# Rezoning Transportation Analysis

Petition Number: 2023-122

## Revision Log:

Date	Description
10-25-23	First Review (NK)
11-22-23	Second Review (NK)

**EMPIRE COMMUNITIES
REZONING PETITION NO. 2023-122
11/13/2023**

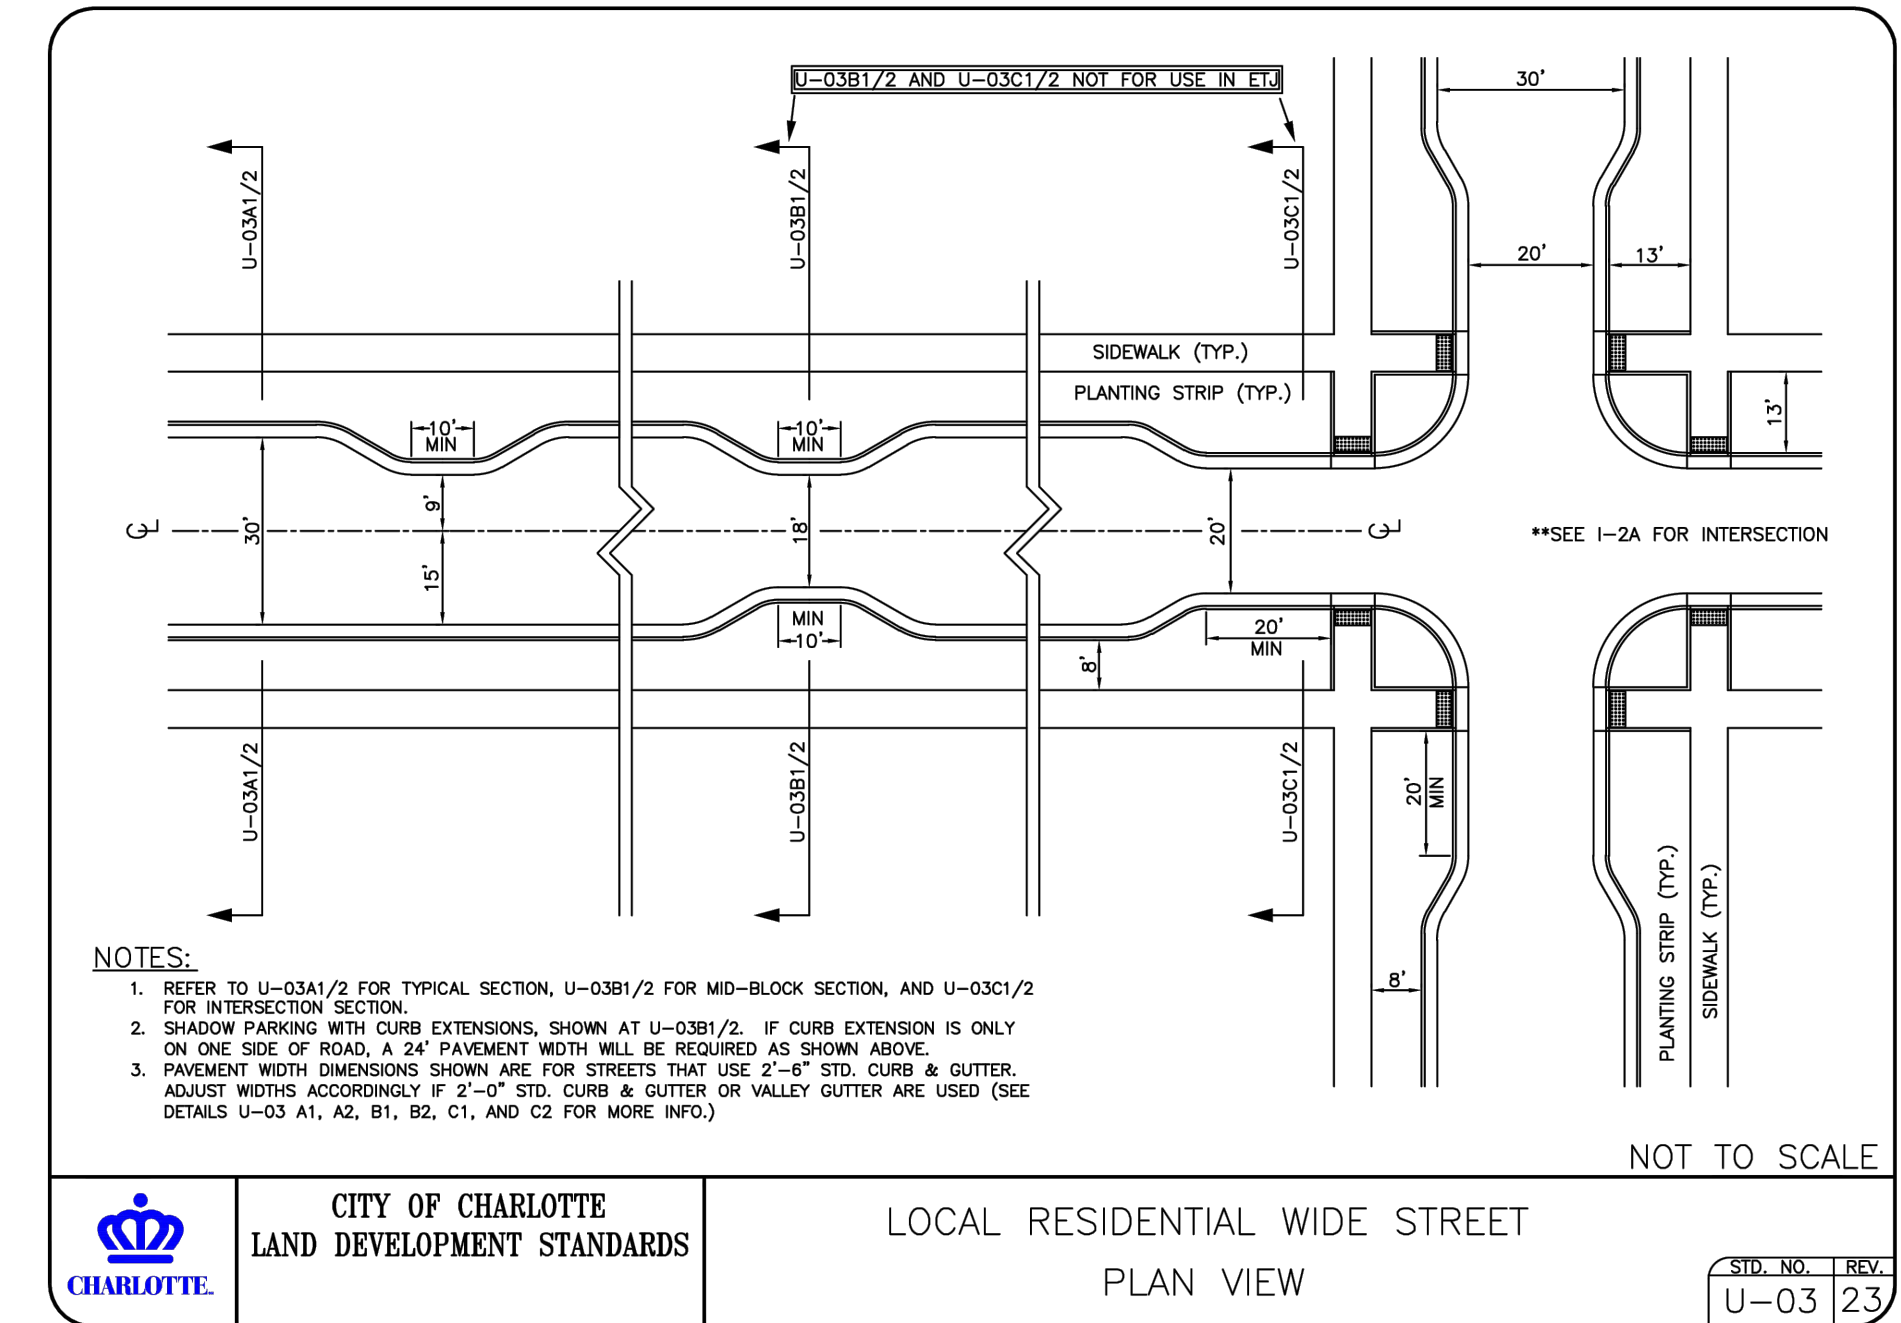
- ~~7. Revise site plan and commit to meeting Public Right of Way Accessibility Guidelines (PROWAG) requirements for on street parking. The required number of spaces can be found in table R211 in PROWAG and design requirements for on street parking can be found in article R310 of PROWAG.~~
- ~~8. Revise site plan to remove crosswalk striping at all unsignalized intersections.~~
- ~~9. Revise site plan to extend Wright Avenue to the property line.~~
10. **Outstanding Comment from 10-25-23** : Revise site plan to include a temporary turnaround for Street A.

**Clarifying Comment:** Since "Street A" is a dead end road, this will require a turn around. See CLDSM 11.18A for reference.
11. **New CDOT Request 11-27-23** : CDOT requests that the petitioner commit to upgrading the southern portion of pavement section along Jenkins Avenue east of the proposed development. An existing townhome development is committed to upgrading the northern portion of Jenkins Avenue.
